Cove at Woodmore Attached Single Family Development

Subject: Northbay at Lake Woodmoor, SF-16-021, Review 1

**EL PASO COUNTY PLANNING AND COMMUNITY DEVELOPMENT DEPARTMENT**

North Bay at Lake Woodmoor
Lake Fork Dirty Woman Creek
Plan and Profile Sta. 1+00 to Sta. 9+50
El Paso County, Colorado

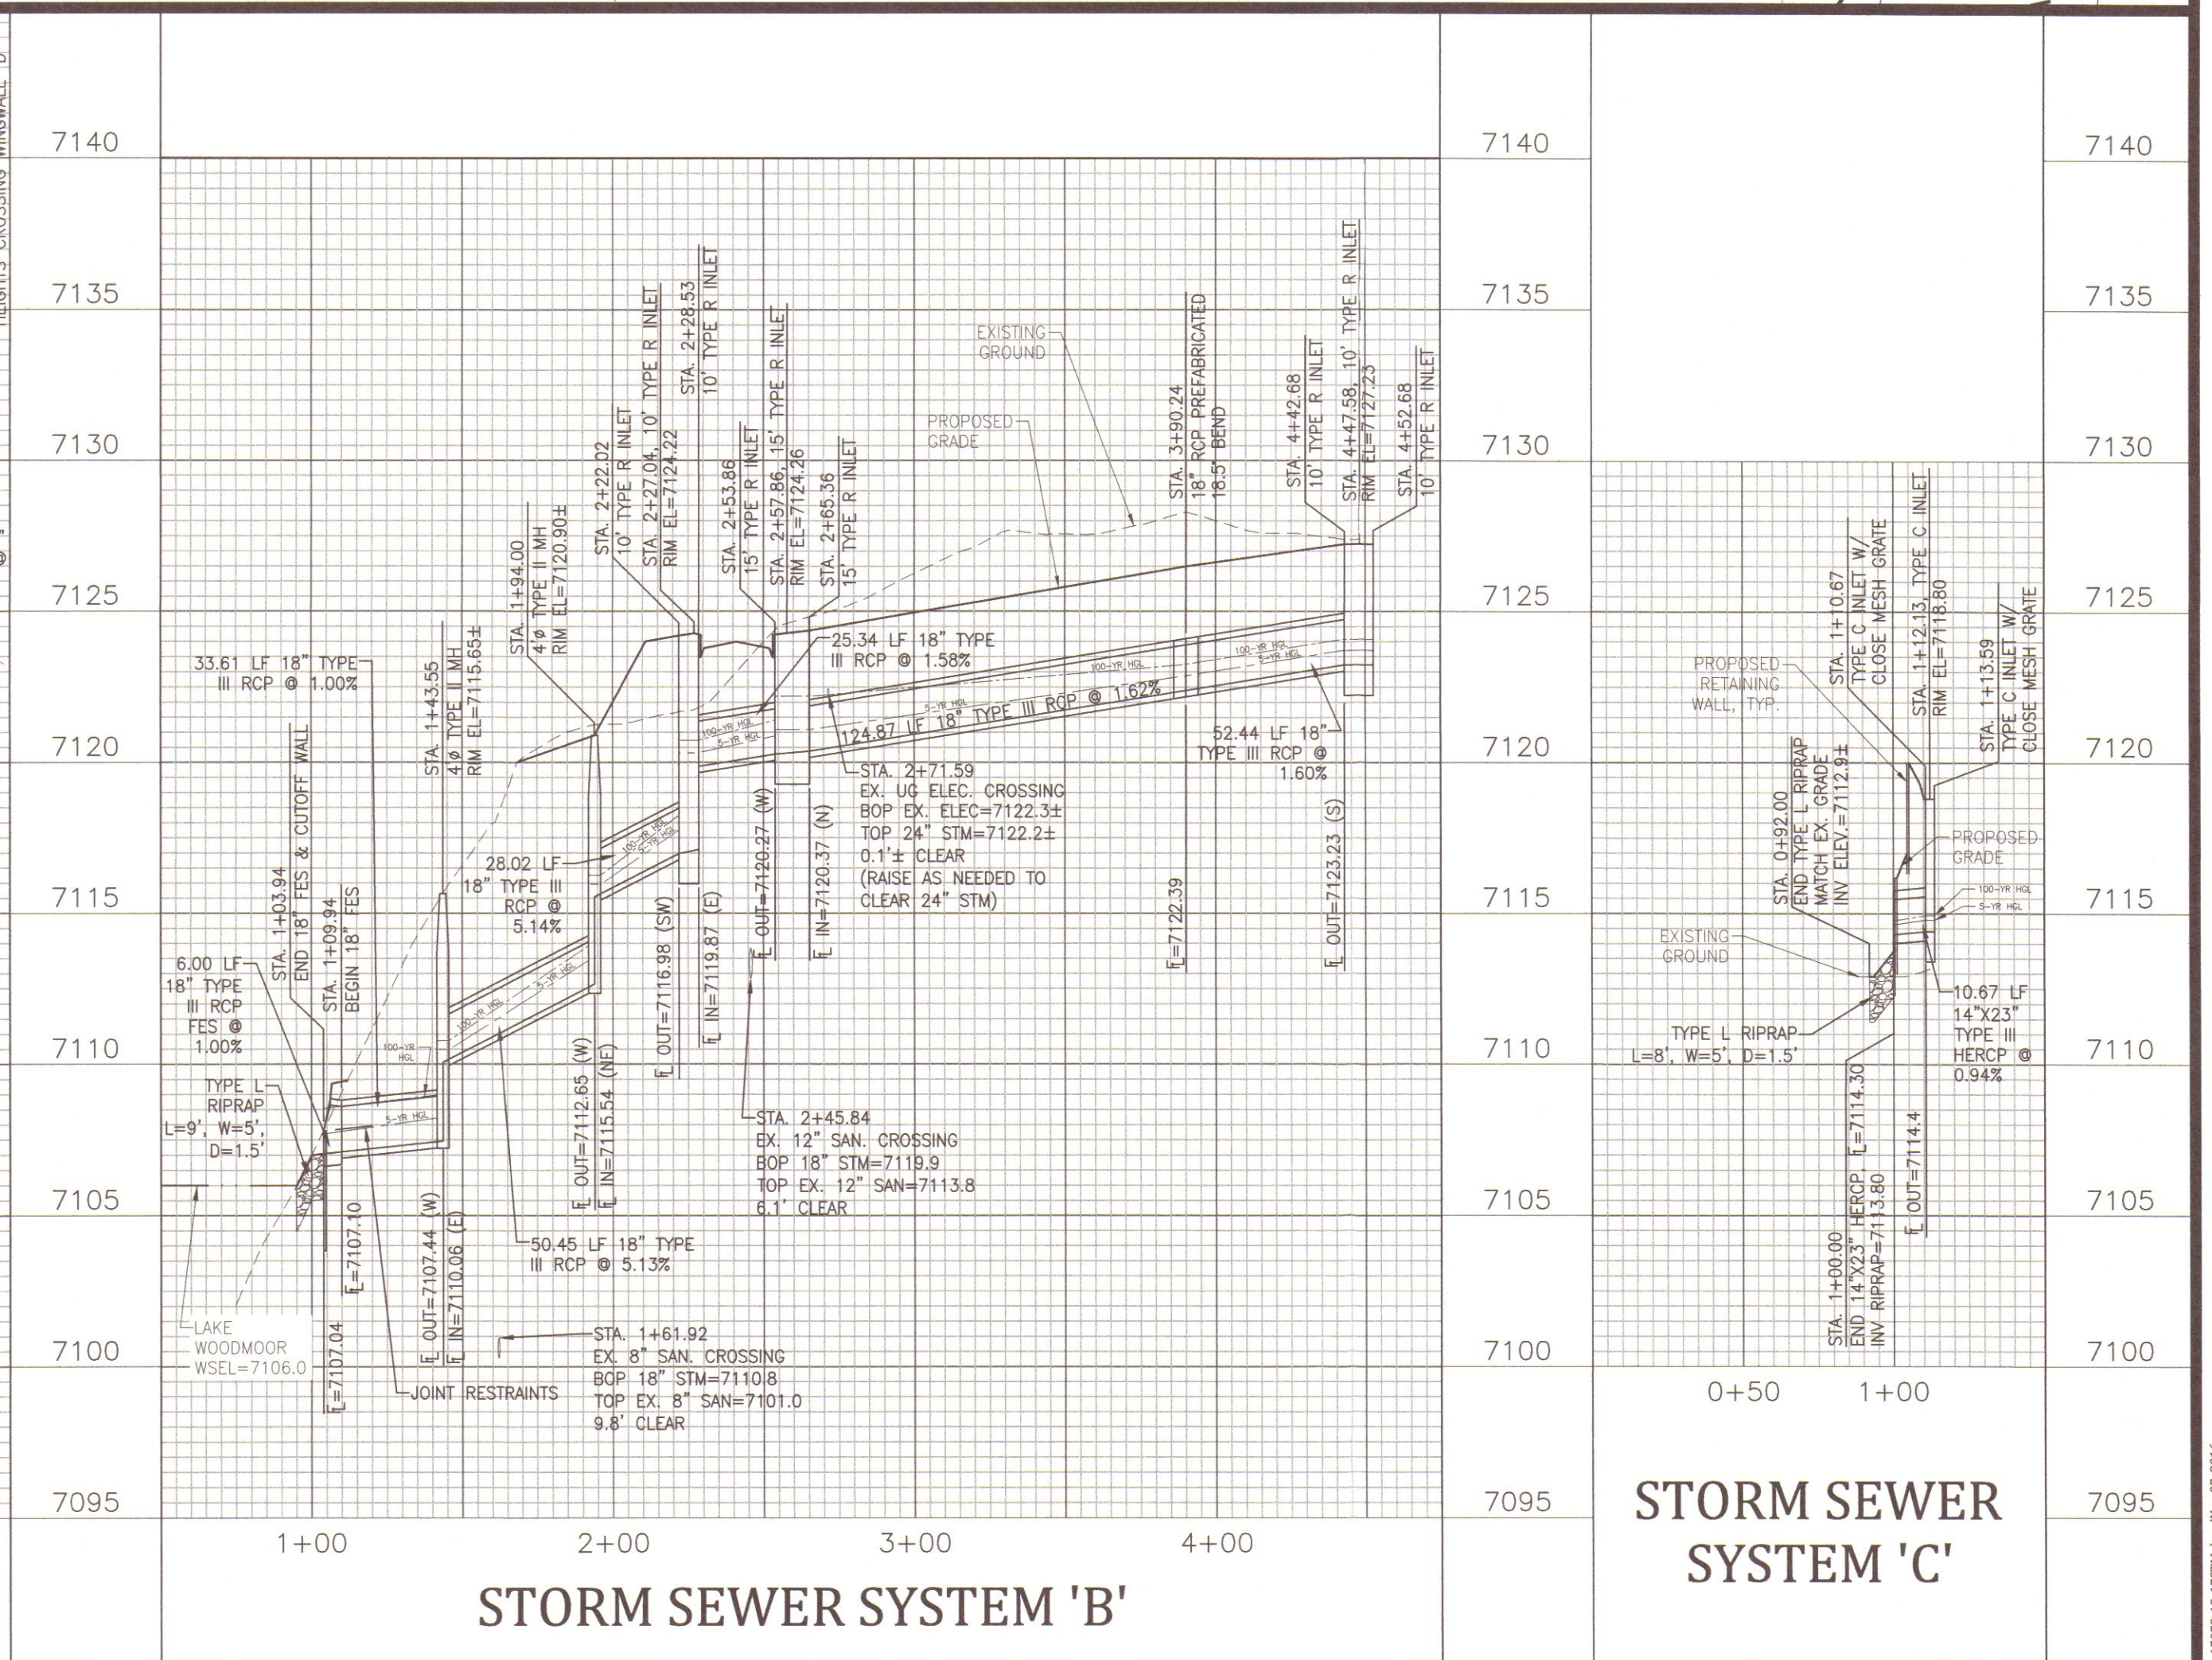
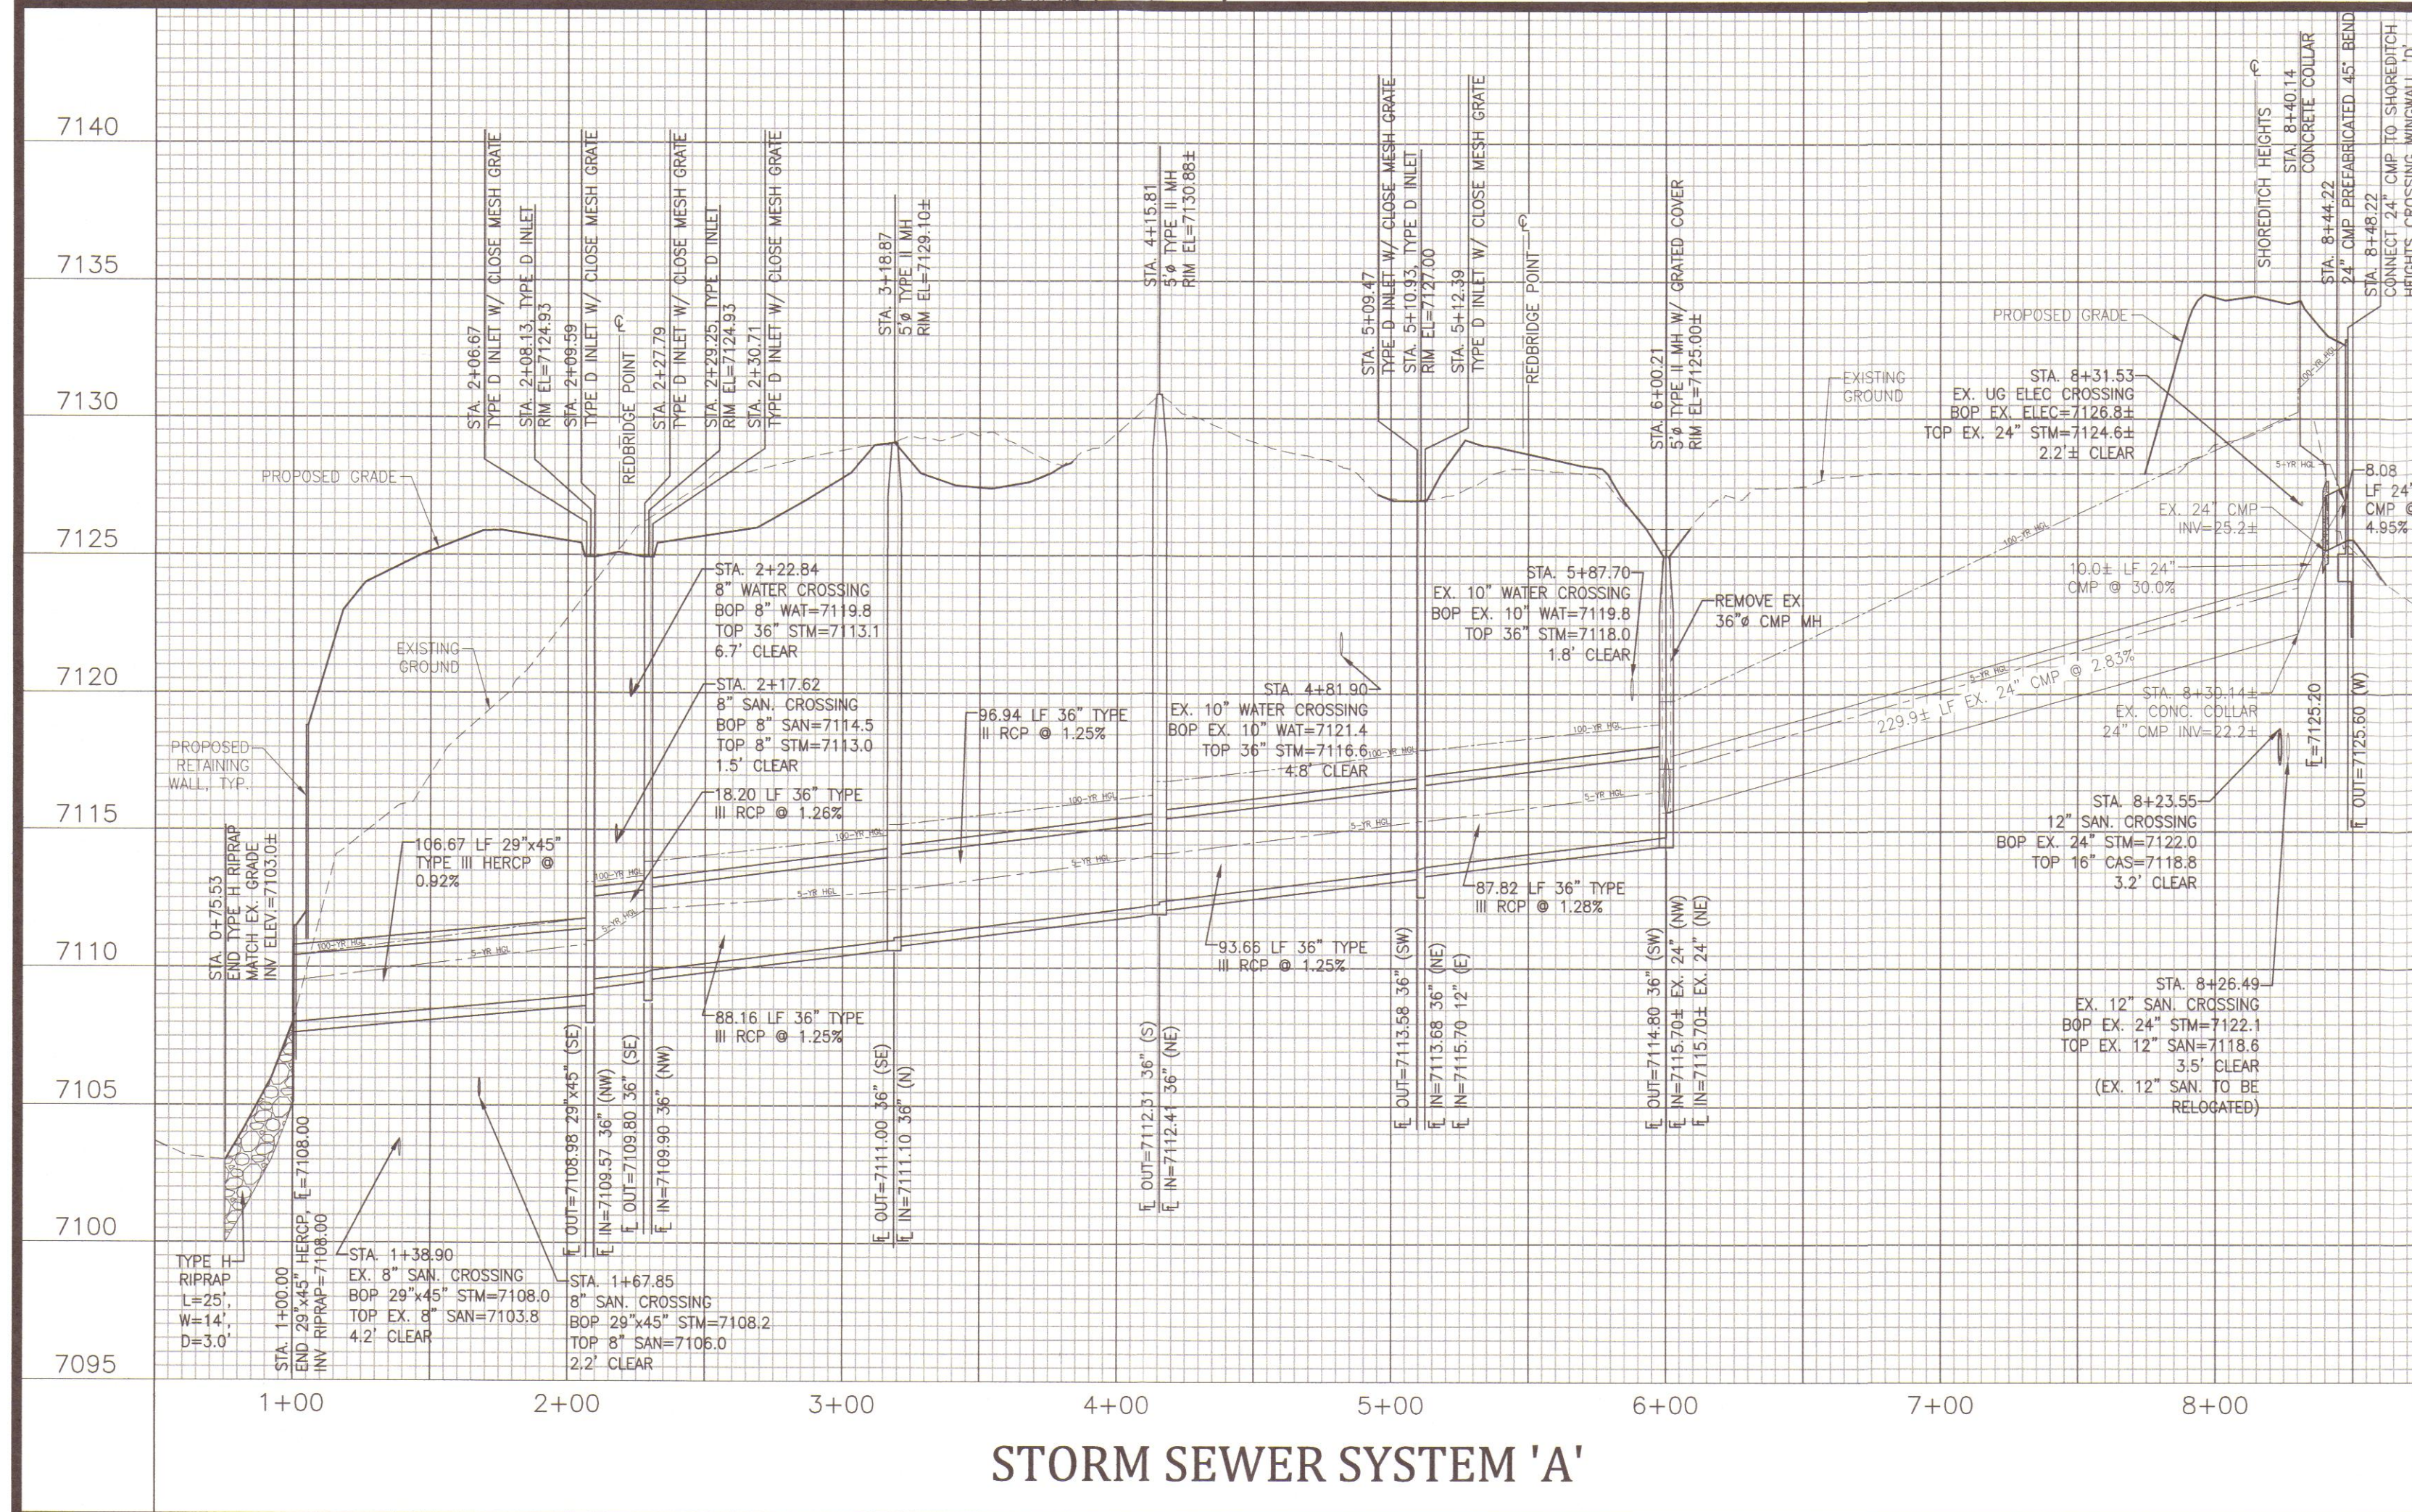
6. HEC-RAS calculation comments:
  - a. Provide an exhibit (plan view) showing the HEC-RAS cross section locations. Additional cross sections may be required.

- b. The summary table for the proposed condition shows sections of the channel exceeds the DCM permissible mean velocity for native grasses (DCM Table 10-4). Froude numbers are also at critical or supercritical. Per DCM 10.7, the channel should be designed for Froude numbers less than 0.9. Update the channel design to comply with the DCM for open channel design. Alternatively, conduct shear stress calculations and see if the results are within the allowable shear for native grass. Typical allowable shear for long native grass are 1.2 – 1.7 lb/sf and short native and bunch grass are 0.7 – 0.95 lb/sf. See HEC No. 15.

- c. Adjust the manning's n value going through the culvert (RS=783) to 0.013 for concrete.
  - d. The overbank n value should be smaller at the retaining wall areas since the material is concrete.

- e. Provide a narrative summarizing the results of the HEC-RAS calculation.
  - f. Evaluate the channel bend stability and additional freeboard at the bend because of superelevation. Will there be local scouring at the pocket area to the west of the channel bend near station 6+50 to 7+00? Additional protection may be needed downstream of station 7+21.
